Subject: 19/01531/F and 19/01763/LB - The Old Post office, Main Street, Sibford Ferris

Thank you for consulting the Design and Conservation Team on the above application. The current applications relate to revised plans for consented application 17/02372/F and 17/02373/LB.

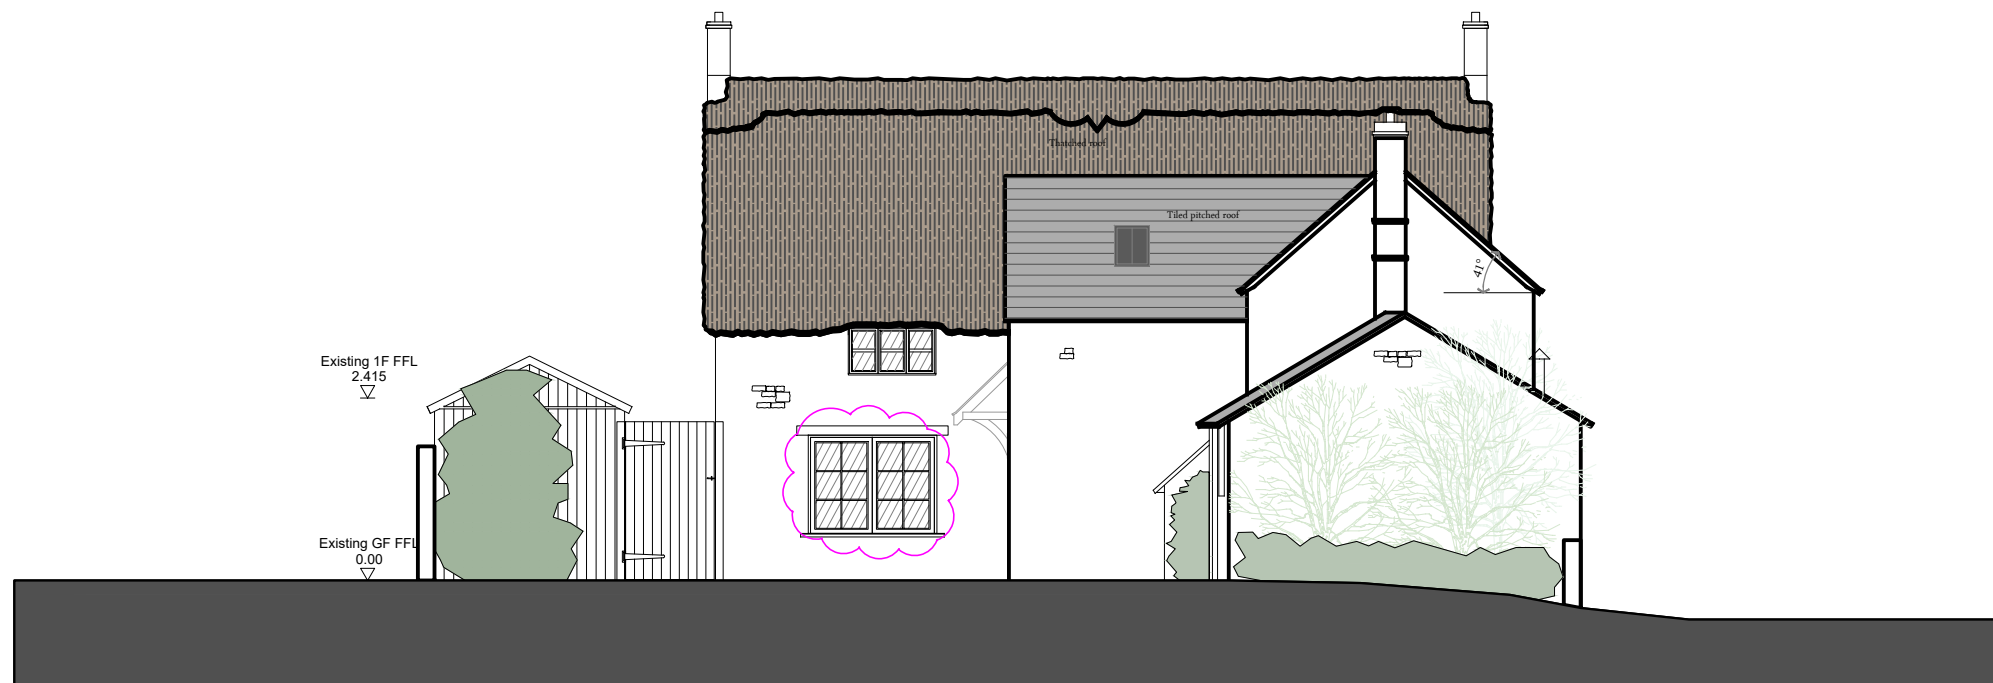
There are concerns with the proposals to provide additional door openings on the rear garden. This will involve the loss of historic fabric including stone walling and traditionally proportioned windows. This proposal is considered to cause additional harm to the building and should be resisted.

There is also a proposal to include additional rooflights to the outbuilding range of the building. The planning statement indicates that this is to provide additional daylight into the kitchen. The additional roof light on the internal façade facing the garden is considered proportionate, but there are concerns with the additional rooflight to the exterior face on the building which will impact on the conservation area as well as the listed building.
